Zoning Committee

Current Zoning: R-4 (single family residential), I-1 (light industrial)
Proposed Zoning: R-8MF(CD) (multi-family residential, conditional)

Approximately 21.50 acres located on the west side of Old Plank Road, east of Brookshire Boulevard, and west of Dale Avenue. (Council District 2 - Graham)

Mattamy Homes

CONCEPTUAL SITE PLAN
 PETITION NUMBER 2022-057
 Old Plank Road Site

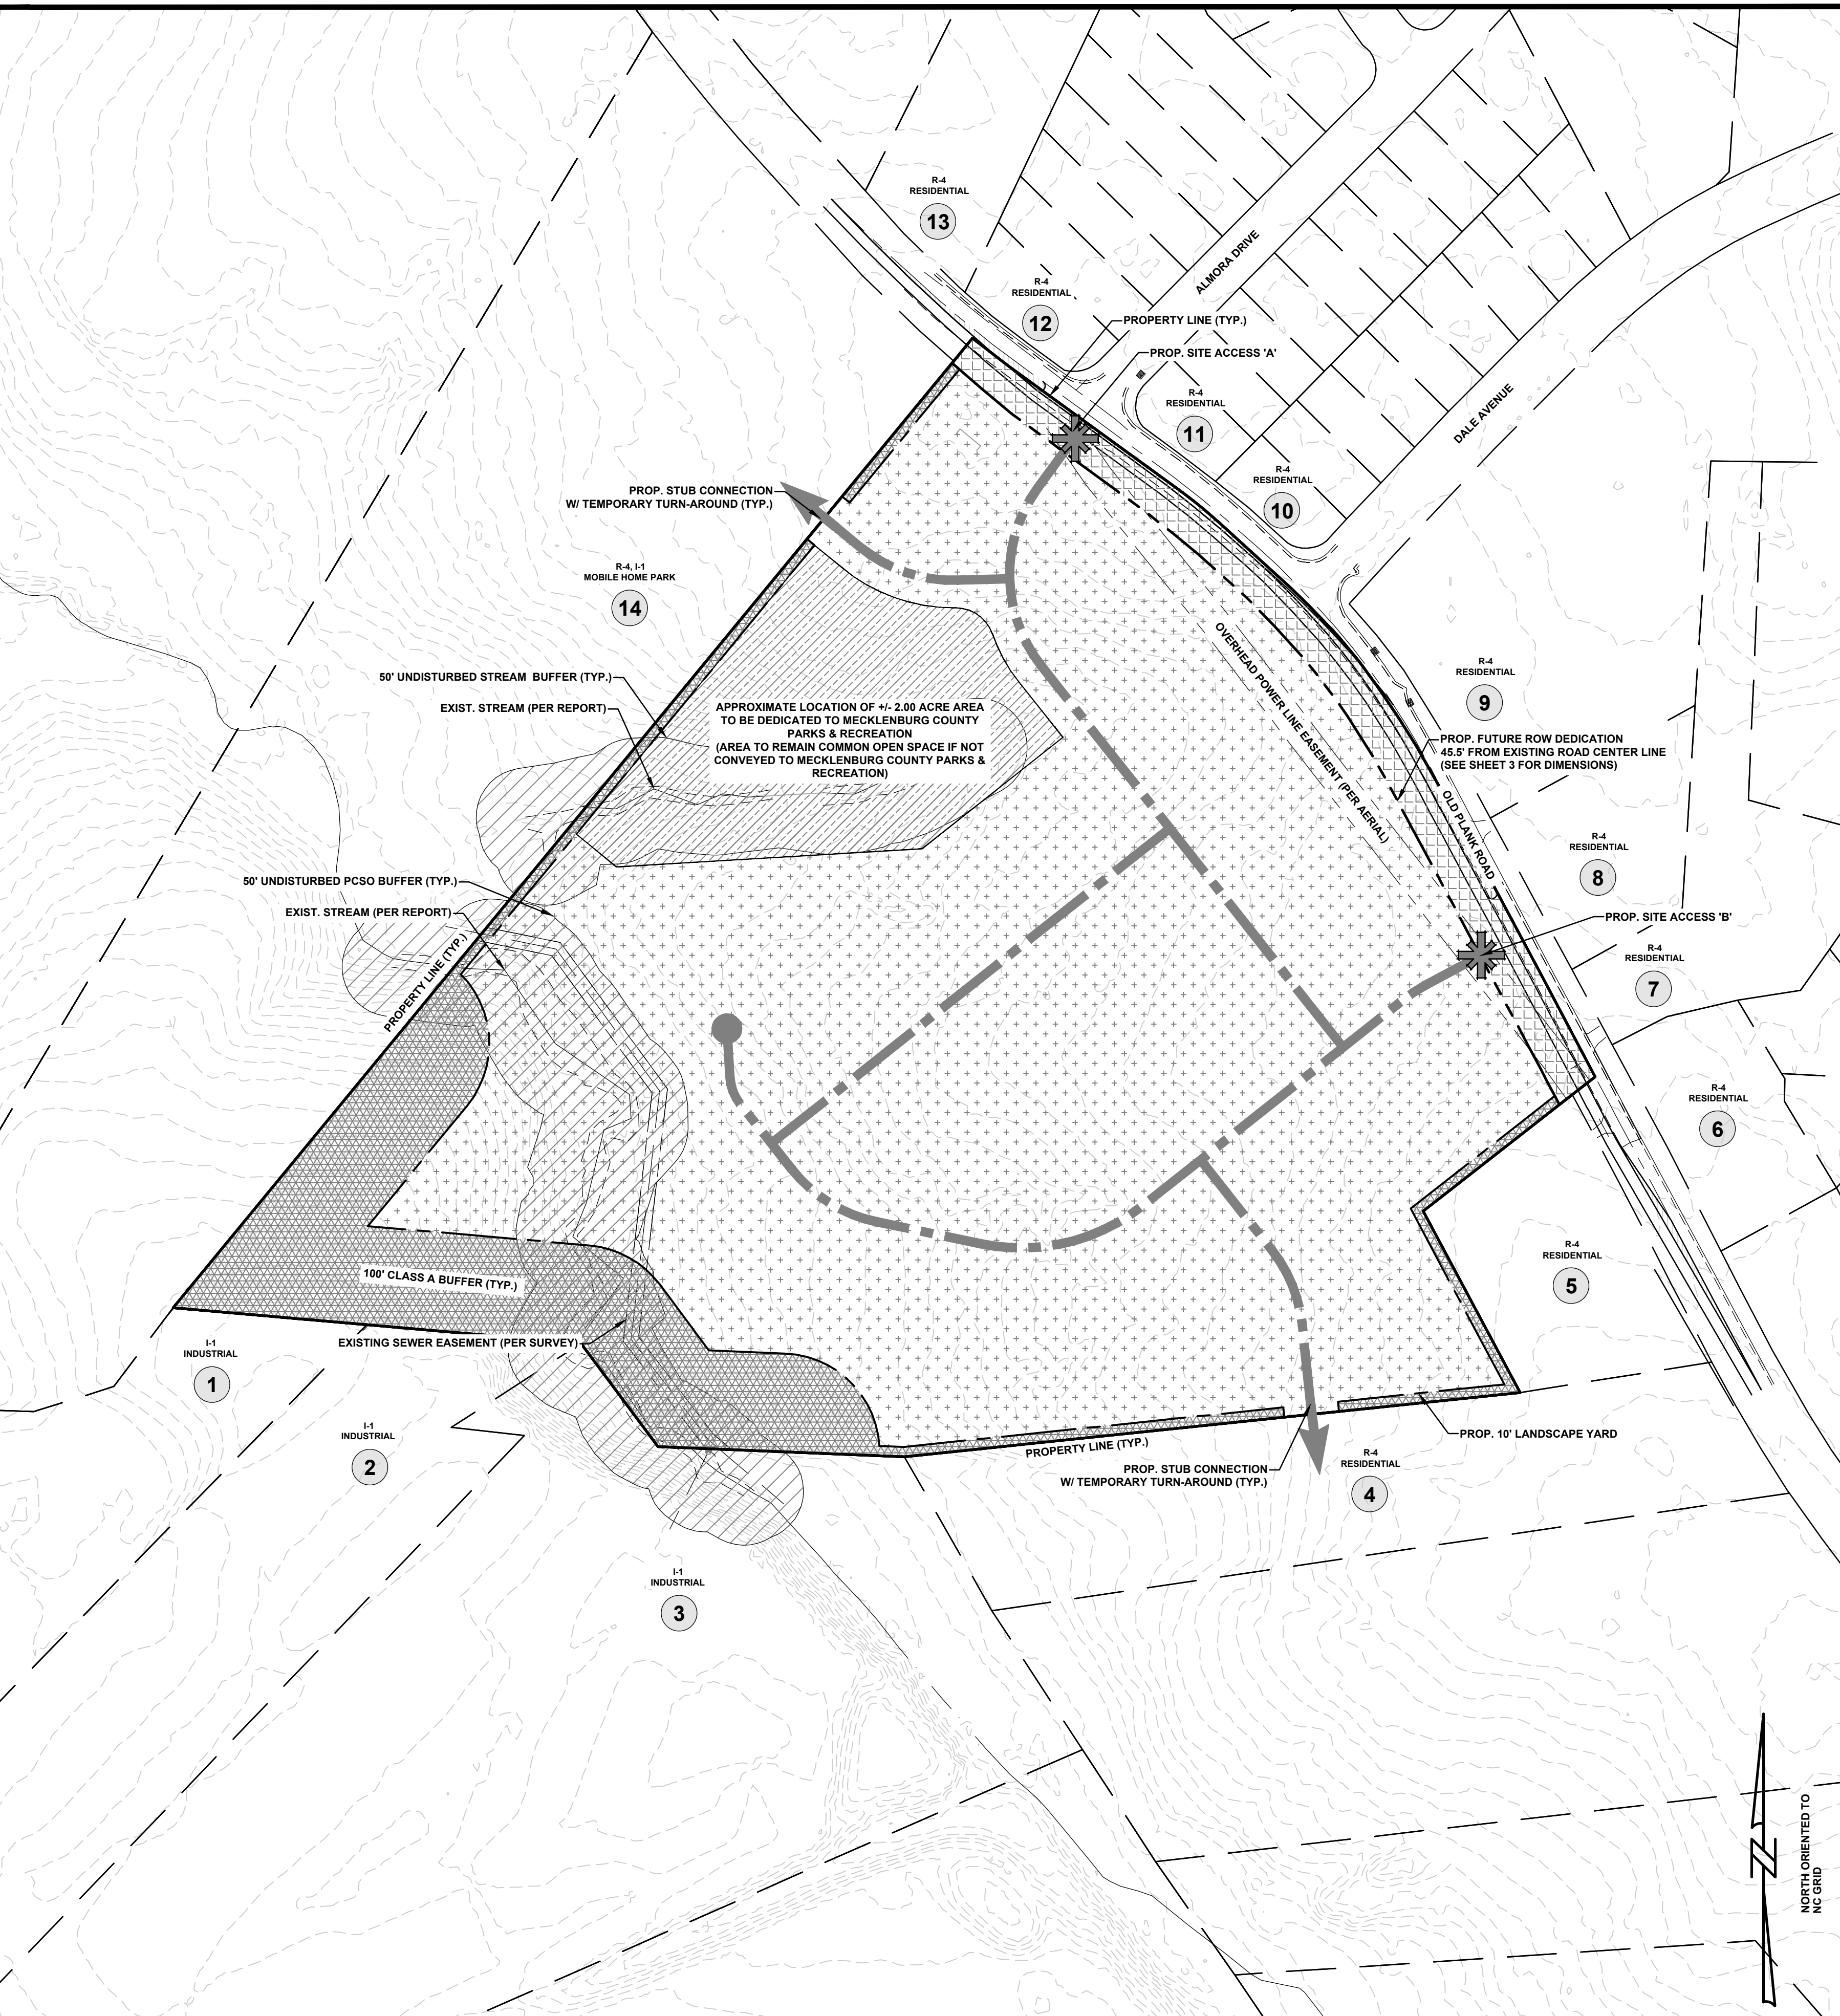
Commissioner Harvey asked why the overhead powerline easement was not changed or adjusted. Staff responded that the easement can be adjusted during the permitting process, but we don't have any control or authority over that in the entitlement process.

Commissioner Rhodes asked if there was a resolution to the road width on Old Plank Road. CDOT responded that the petitioner would install left-turn lanes on Old Plank Road at the proposed site access points A and B with each turn lane containing a minimum of 100-feet of full width storage and a dedication of right-of-way with an 8-foot planting strip and 6-foot sidewalk and a 5-foot bike lane along the site's frontage on Old Plank Road.
